Application by Chrysaor Production (UK) Limited for an Order Granting Development Consent for the Viking Carbon Capture and Storage Pipeline

The Examining Authority's first written questions and requests for information (ExQ1)

Published on Wednesday 3 April 2024

4.14 Washingdales Lane Block Valve Station Plan and Elevations

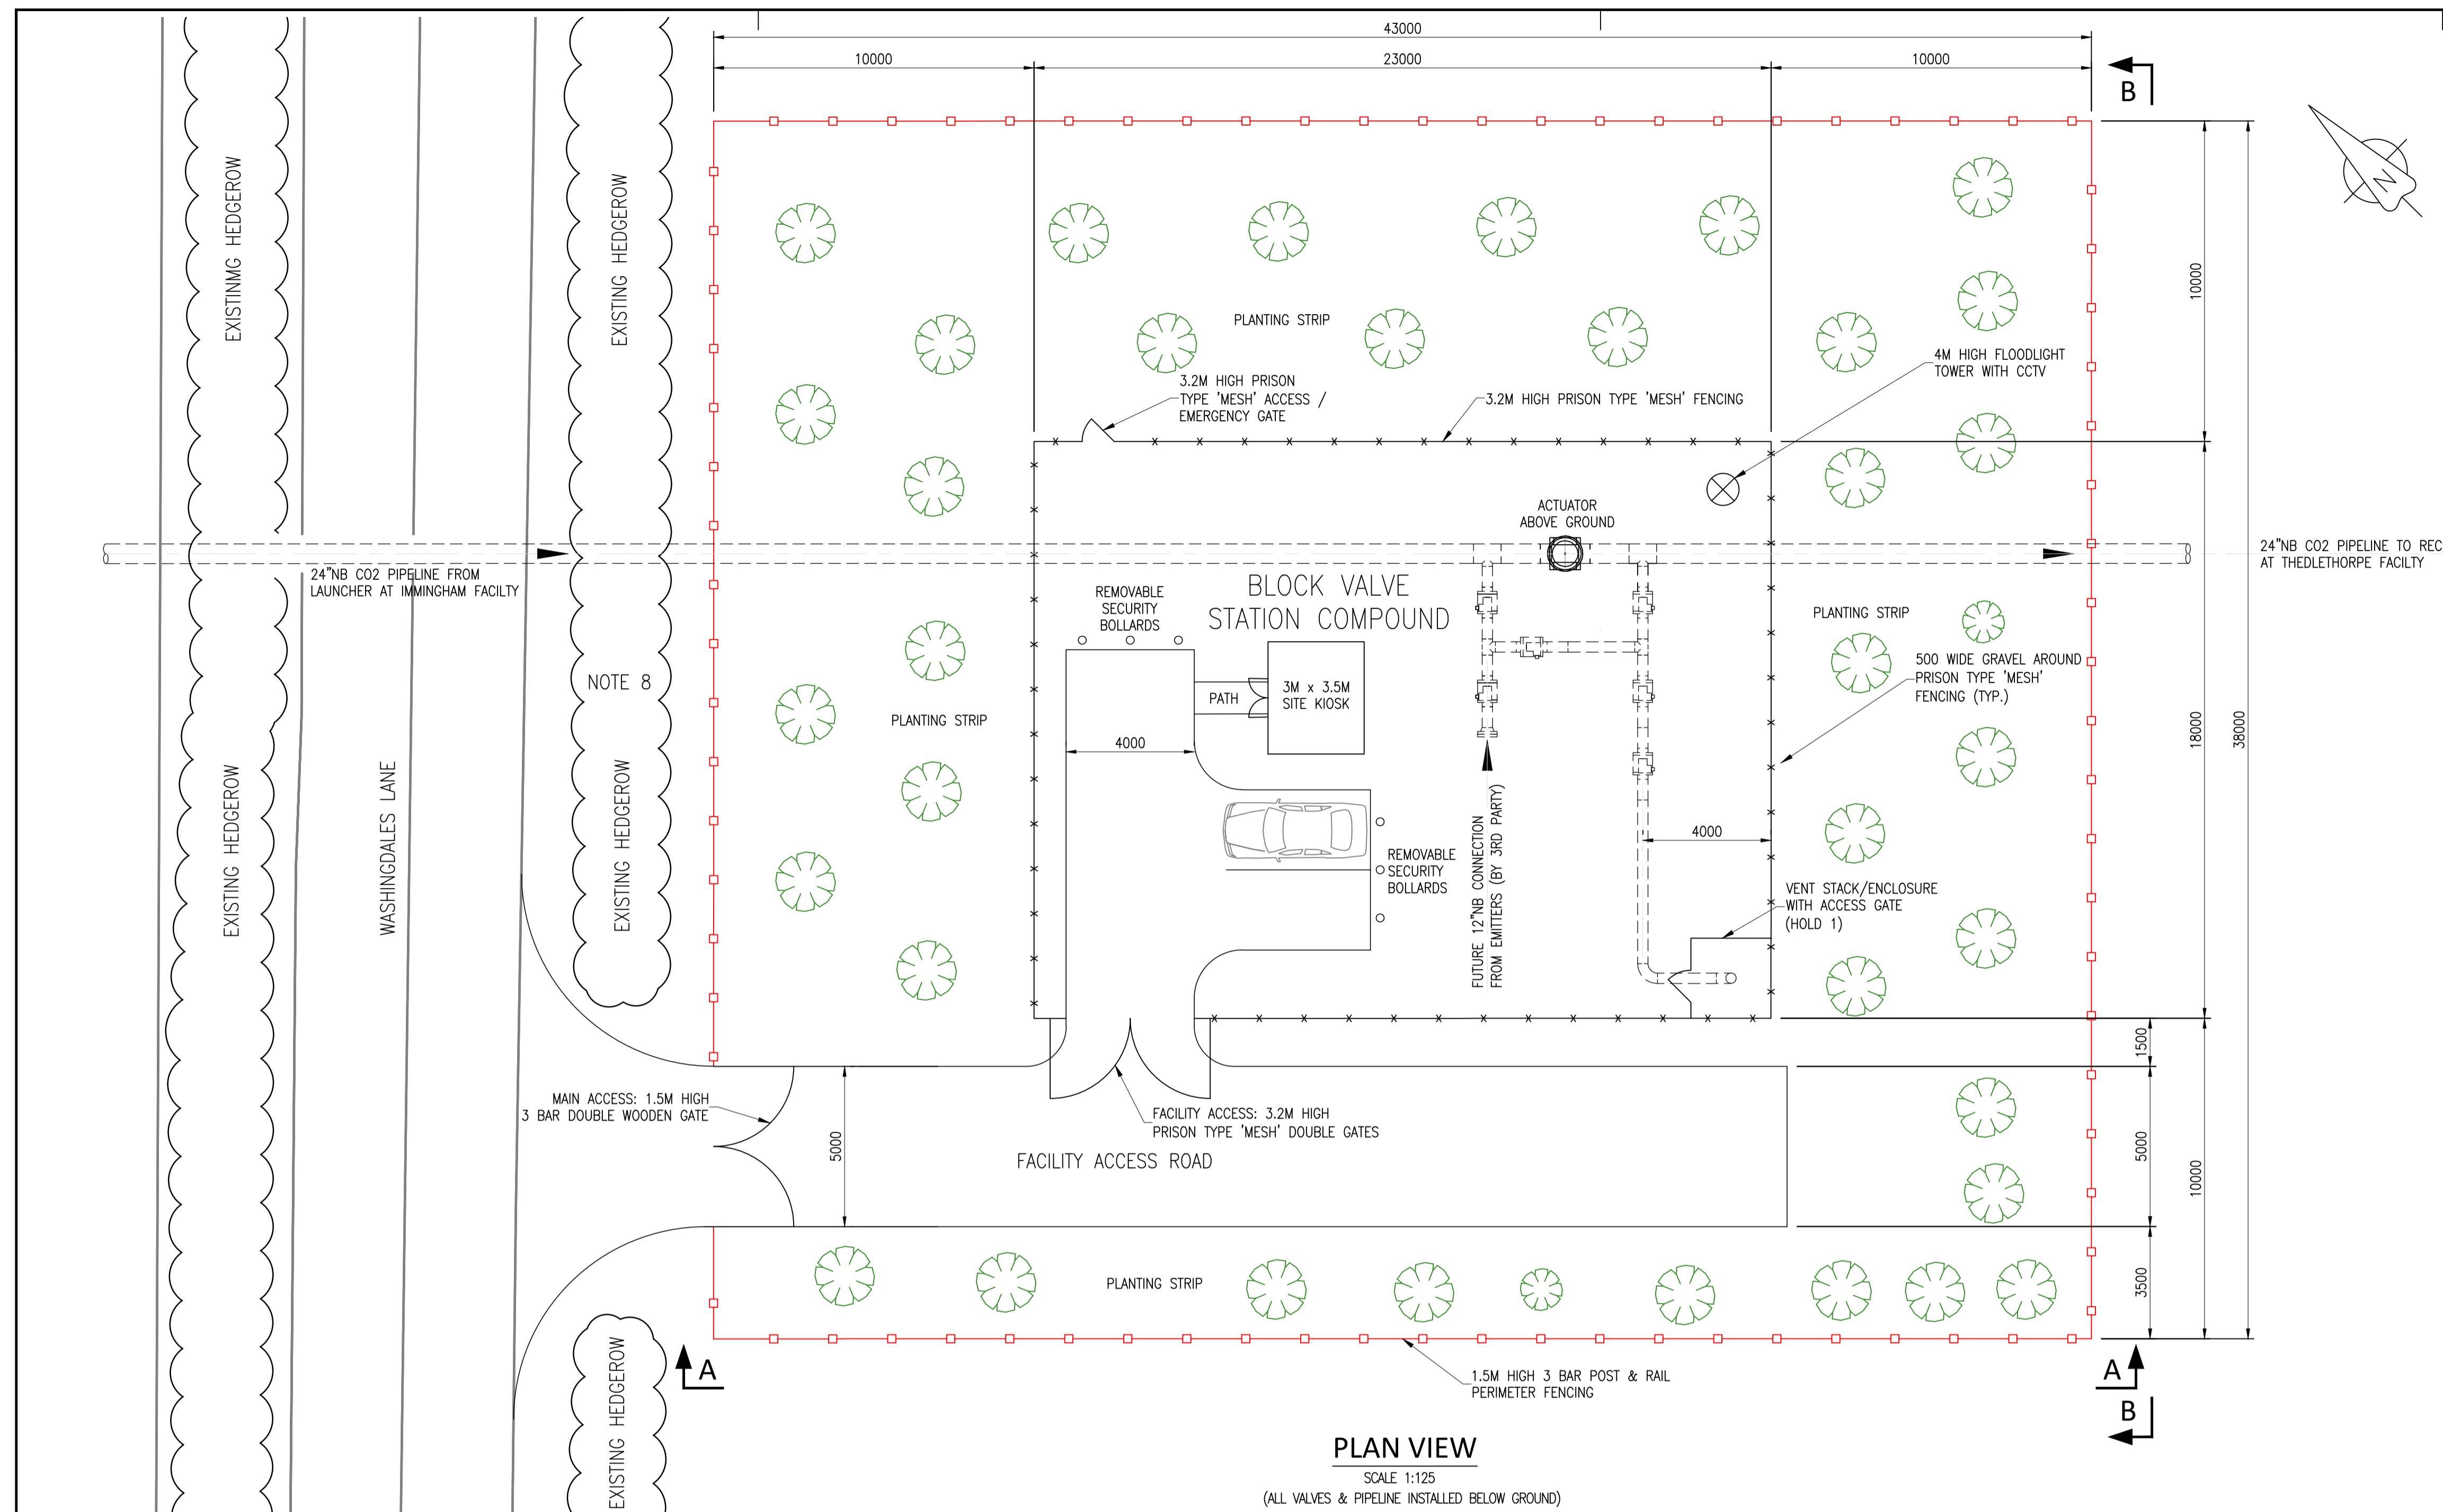
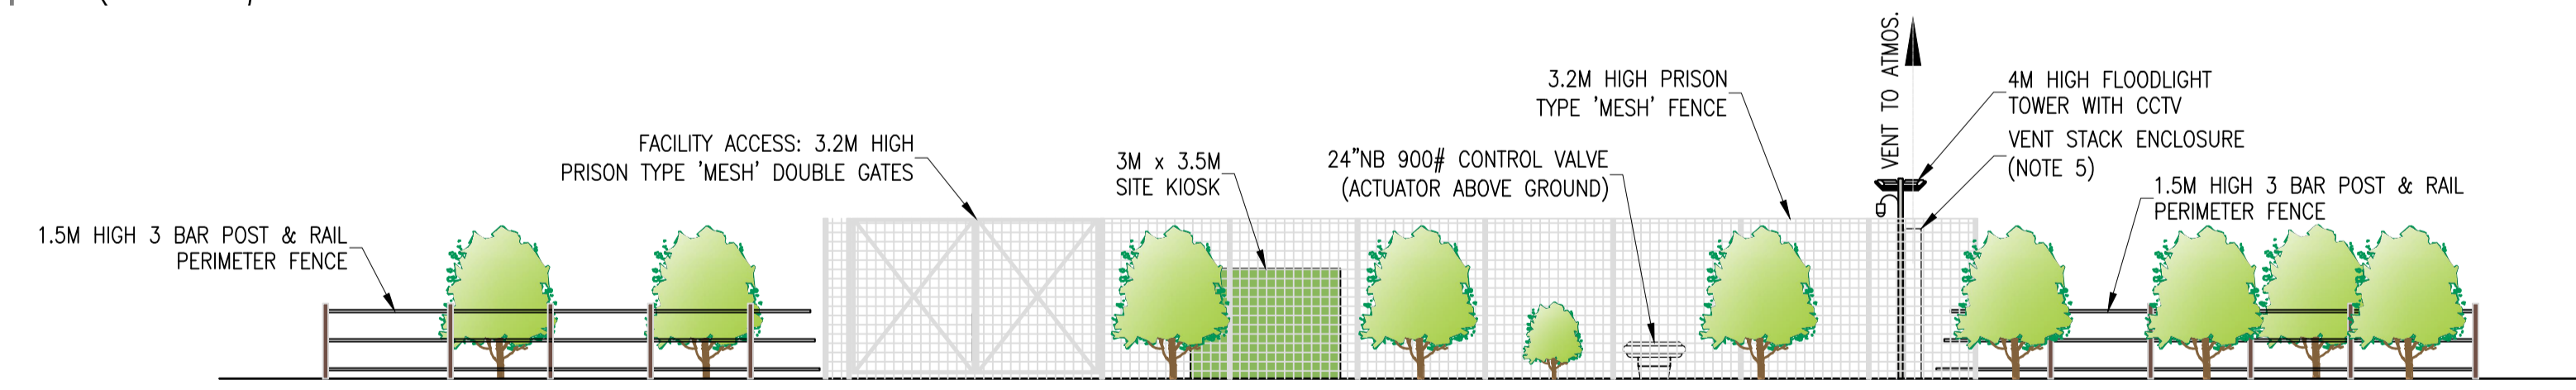
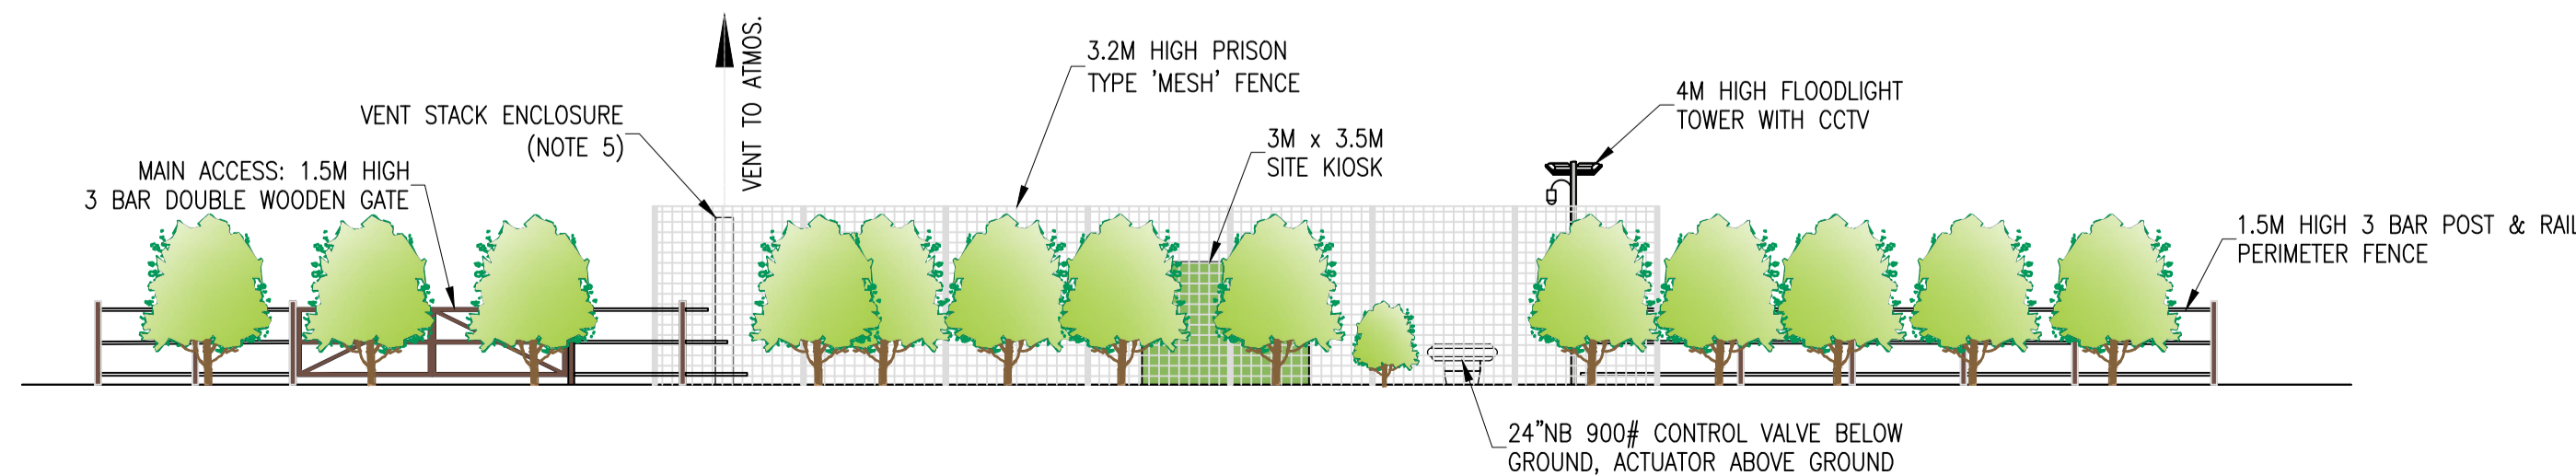
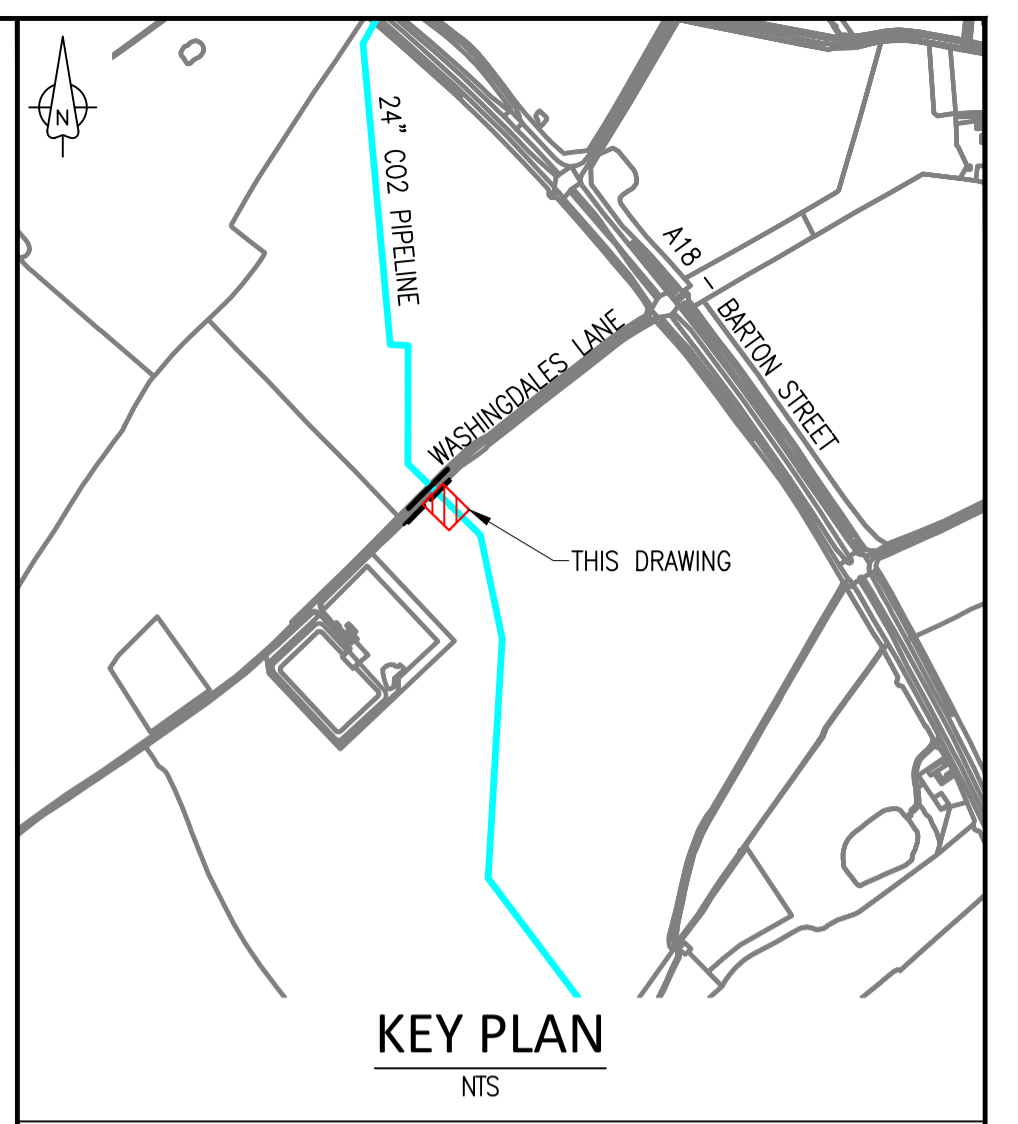
1.3.6	Applicant	<p>Block Valve Station proportions</p> <p>The ExA note from the Statement of Reasons (SoR) [AS-013, Paragraphs 6.1.8 - 6.1.10] that the northernmost BVS is said to have a permanent land take of 43x38m. However, the other two block valve stations are said to require 50x40m area each. Why is there this difference and why cannot the smaller BVS model be applied consistently across the scheme?</p>
